**KIRKLEES METROPOLITAN COUNCIL
INVESTMENT & REGENERATION SERVICE**

Reference No:	2025/62/90154/E
Site Address:	16, Hopton Hall Lane, Upper Hopton, Mirfield, WF14 8EN
Description:	Demolition of existing garage and erection of two storey rear extension
Recommending Officer:	Joanna Rednall

HOUSEHOLDER DELEGATED REPORT

Client	
Mr Scott & Miss Jones	
Job	
16 Hopton Hall Lane Mirfield	
Title	
Proposed Elevations and Floor Plan	
Drawn By	Date
RK	Jan 2025
Eng. Check	Scale
	1:100
Tech. Check	
Drawing No.	Rev.
2024 / 458 / 02

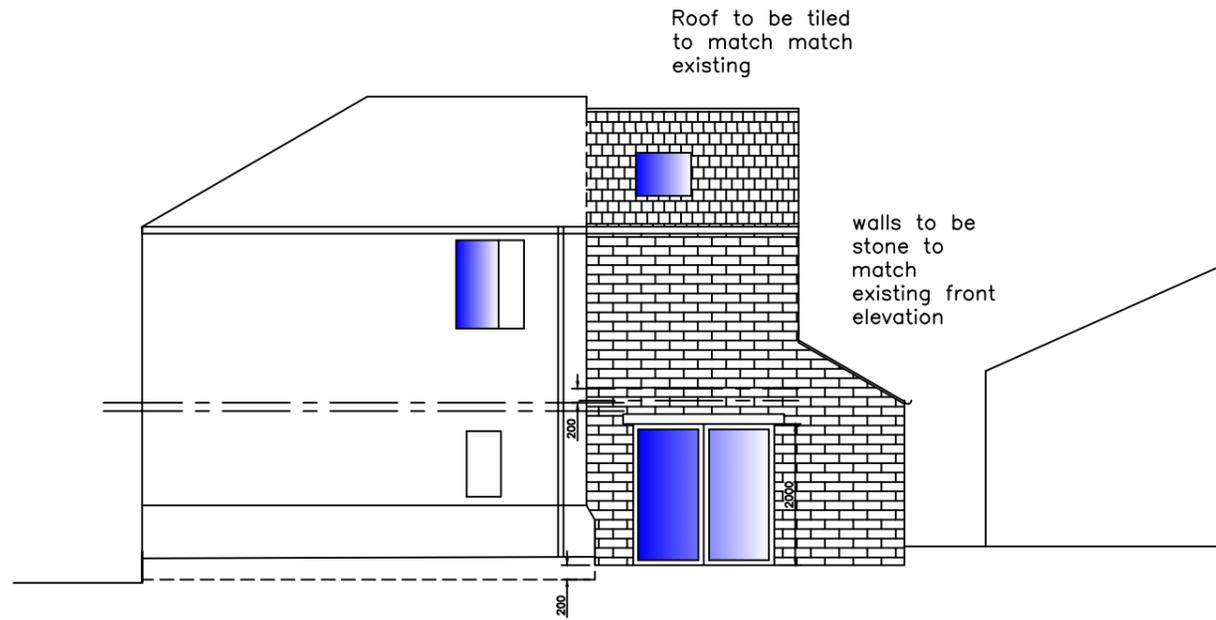
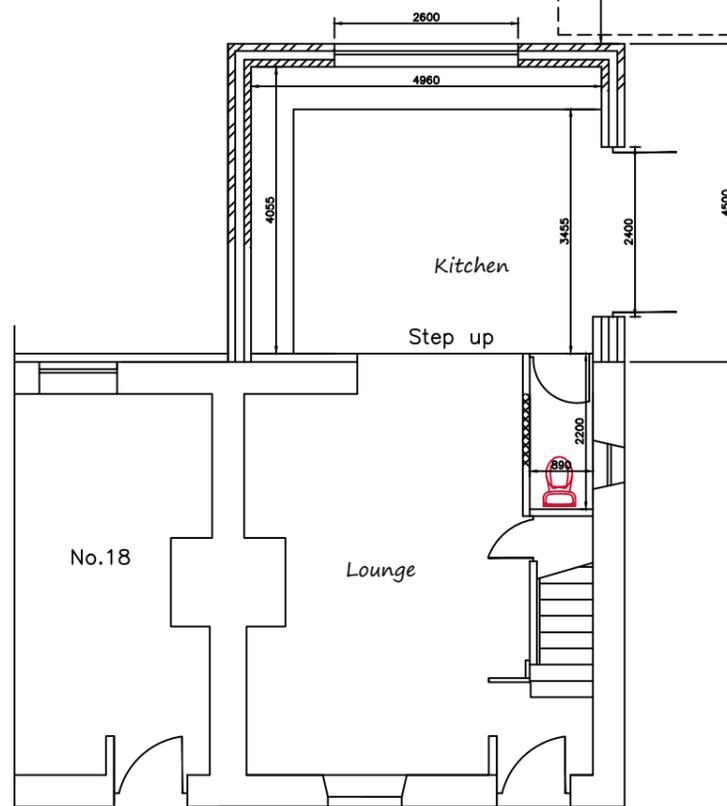
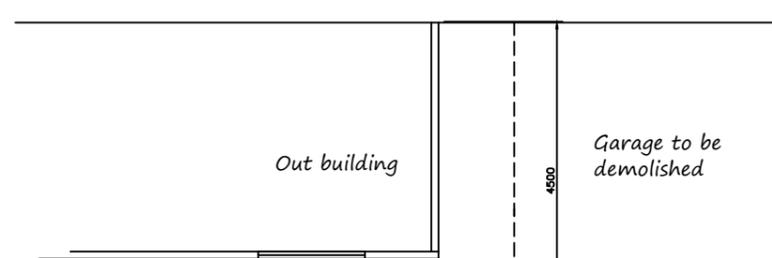
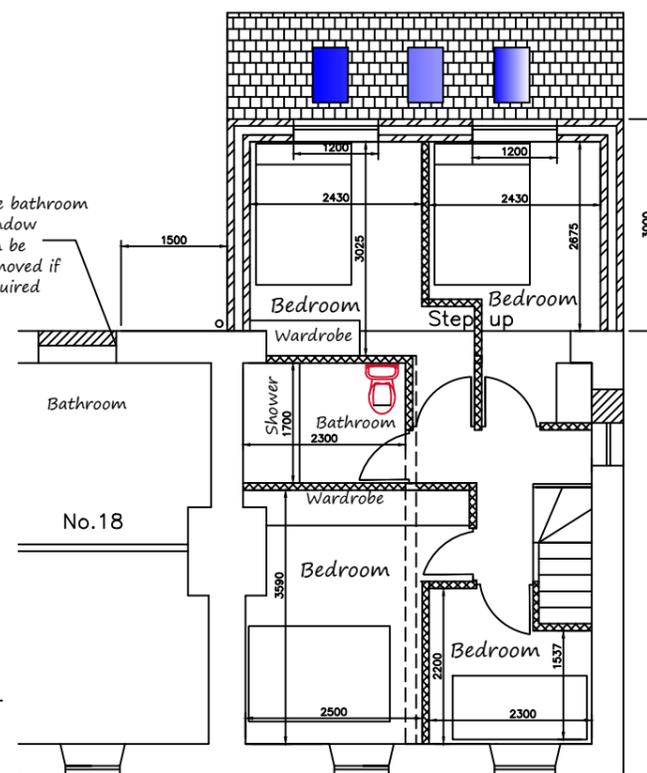
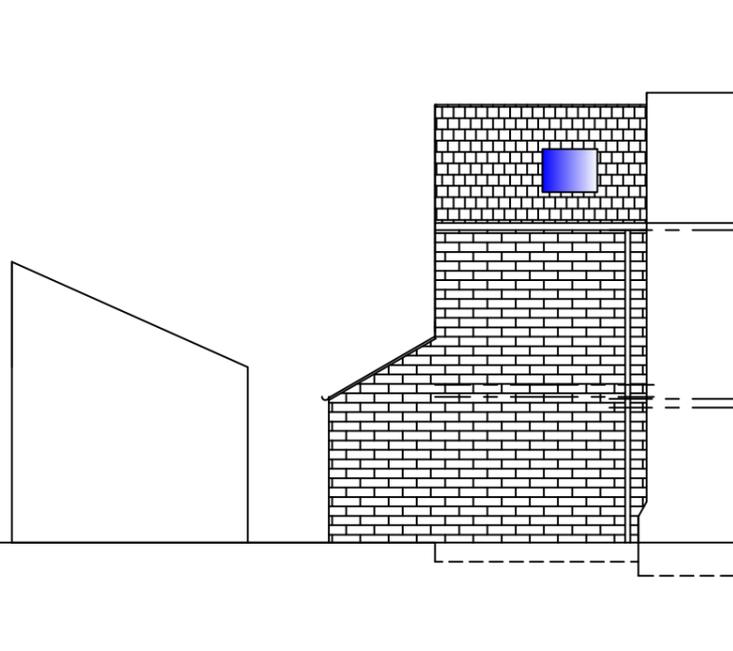
The extension projects ~4.5 meters at ground level and ~3 meters at the first floor, with a total width of ~5.6 meters. The ground floor includes a lean-to roof with three rooflights, while the roof over the two-storey element is pitched. The exterior walls are finished in stone, to match the existing front elevation, and the roof is covered in tiles that match those of the main property.

The single storey element of the proposal has an eave height of ~2.3 metres and ridge height of ~3.2 metres, and the two-storey element has an eave height of ~4.8 metres and ridge height of ~6.4 metres.

It is considered this neighbour would be most impacted by the development. The proposed development would extend ~4.5 metres along the common boundary at ground floor level and ~3 metres at first floor level.

Regarding KDP 5 of the SPD, which addresses overshadowing and loss of light, it appears the proposed development would intersect a 45° line drawn from the closest habitable window of No. 18 to the corner of the extension. The applicant's agent has confirmed that this window serves a kitchen. According to paragraph 4.18 of the SPD, development that deviates from the 45° rule may still be acceptable if the sun's orientation offers mitigating factors. To assess the potential overshadowing on the rear amenity space/habitable windows of No.18, sunlight calculator software has been used. Given that No. 18 Hopton Hall Lane is situated on the south-west-facing elevation, it is concluded that the proposed development will not cause significant overshadowing of the rear amenity space or habitable windows, with any overshadowing being limited to the evening hours. The rear window of No.18 serves a through secondary room, therefore it has been assessed that any potential loss of ambient light would not be detrimental to the living conditions of occupiers of No.18.

Regarding the impact on the first-floor window at No. 16, the submitted plans indicate that this window serves a bathroom and could be removed if necessary. The proposed extension would slightly encroach on the 45-degree line drawn from the centre of this window. However, since the window serves a non-habitable room and considering the orientation of the extension relative to No. 16, the development would not significantly affect the natural light currently received by No. 16 and officers consider it would not be necessary to remove this window. Therefore, the proposal would be acceptable in this case.

In terms of overlooking / loss of privacy, there are no windows proposed to the side elevation facing No.18.

Regarding overlooking and privacy, the submitted plans indicate that a pair of patio doors would be installed on the side/north-west facing elevation. These would be positioned approximately 3 meters from the shared boundary and screened by existing boundary treatments, due to the difference in land levels. As a result, any potential overlooking would not significantly affect the occupants of No. 10.
